DRB Application No.: 04DRB-00655 (SBP) Project # 1003008
 Project Name: SEVEN BAR RANCH
 Agent: Mullen Heller Architecture PC Phone No.: 268.4144

TO: Sheran Matson, Chair, Development Review Board
FROM: Deborah L. Stover, Senior Planner, Development Services
DATE: 5-4-04

SUBJECT: EPC CONDITIONS FOR PROJECT 1003008

1 Site Development Plan for Building Permit
 Scale: 1"=20'-0"

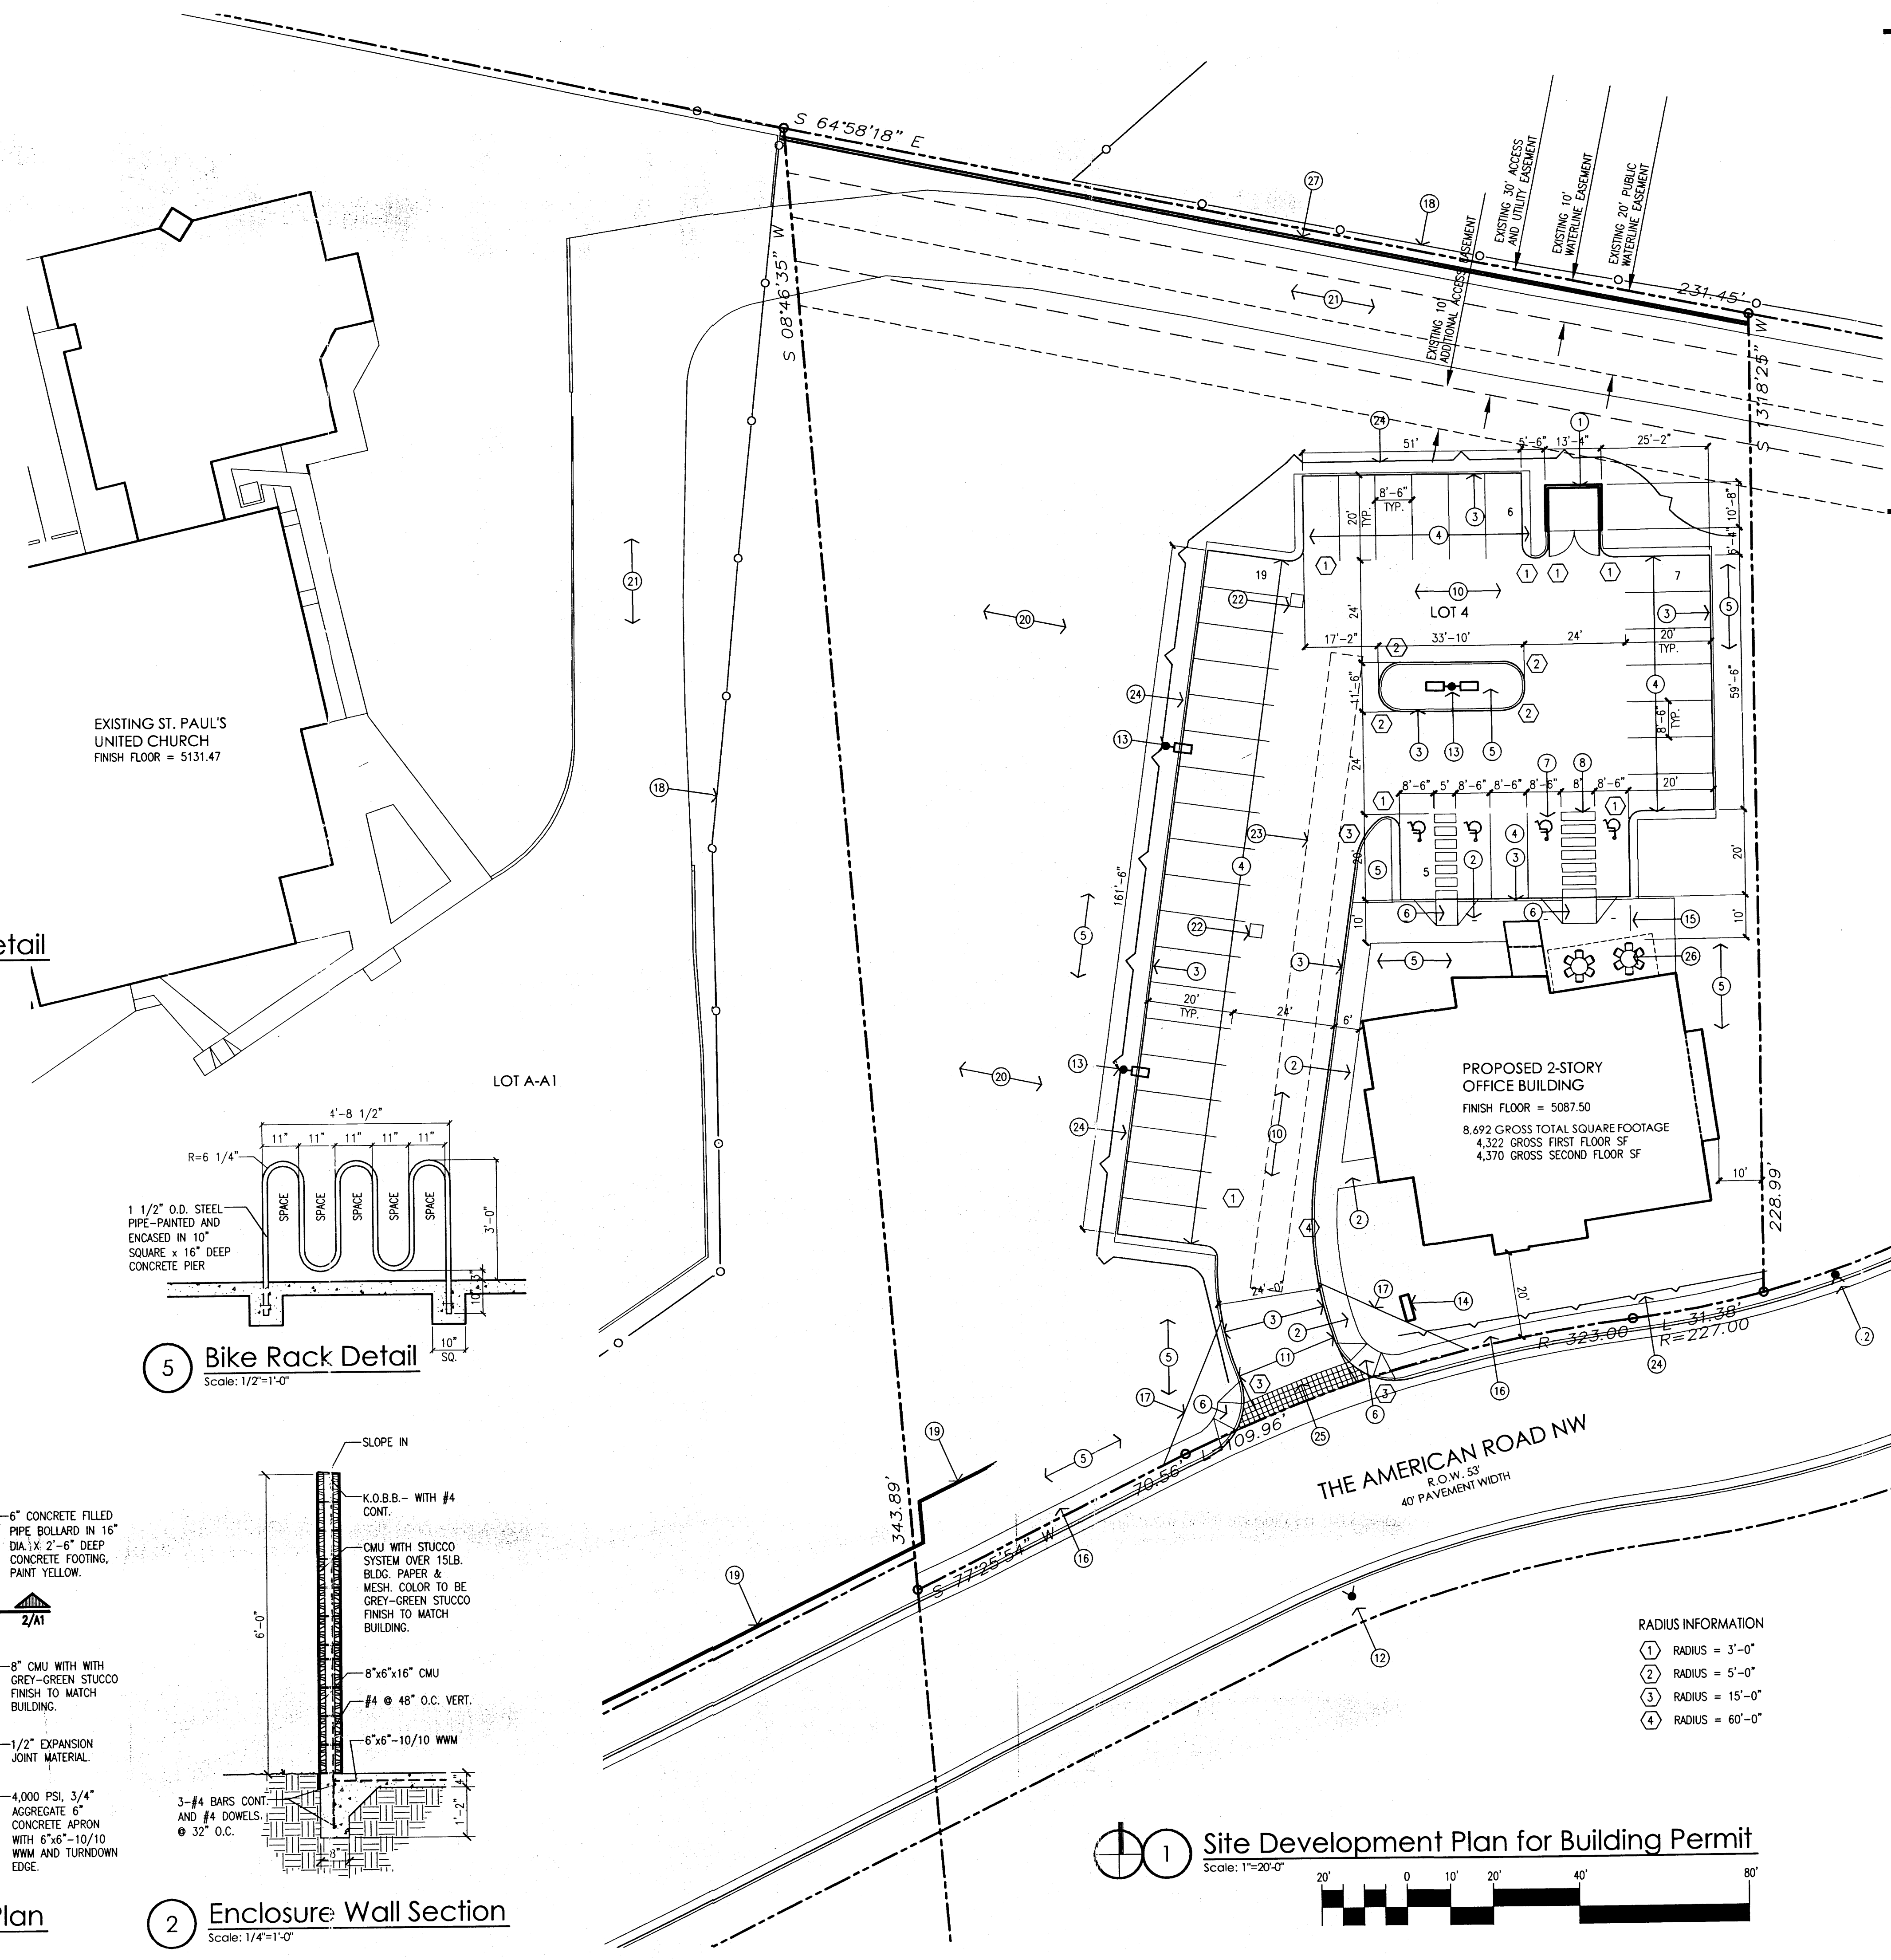
Condition #4: A 6-foot high CMU wall that matches a similar wall to the west shall be constructed between the subject site and the residential property to the north. This wall shall be shown on the site plan prior to DRB approval.

It is not within the purview of City Staff to reconsider a condition imposed by the EPC. Furthermore, the reasons for requesting the City to reconsider this condition were known at the time of the EPC hearing and the agent agreed to them. This was a very important element to the neighborhood - one that allowed the approval to go through with no appeal by the neighborhood. It would not be in good faith to allow this wall to be removed without a public hearing to allow the neighbors a chance to have input.

✓ This agent states that this condition has been met, but staff could not find an area that was labeled 250-square feet that had tables and seating and is shaded. If this area is on the site plan it shall be labeled and tables and seating shall be shown.

4 Light Pole Detail
 Not to Scale

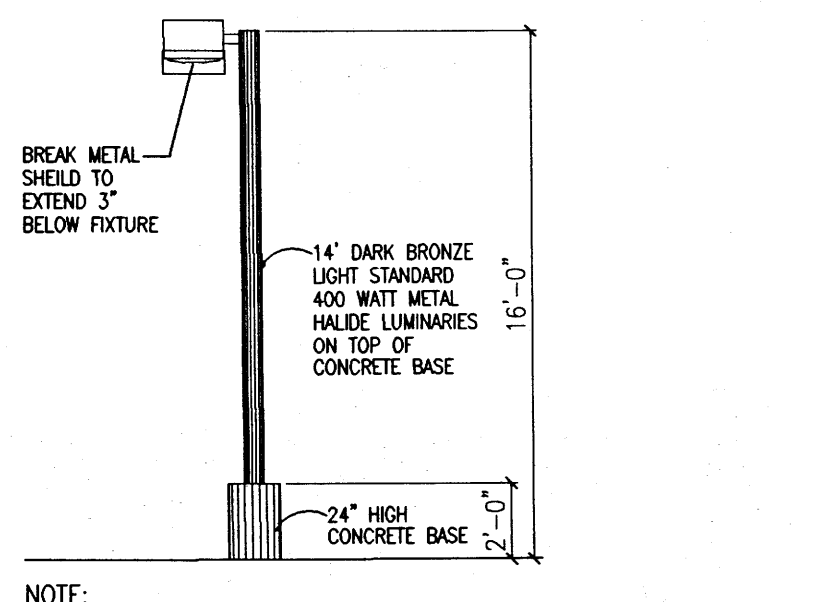
A detail of the light fixture has been provided and complies with the condition, with the exception of the base of the pole being 2-feet in height in addition to the light pole being 16 feet tall. The entire light pole, from base to top, shall not exceed 16-feet if within 100-feet of a residentially zoned property.
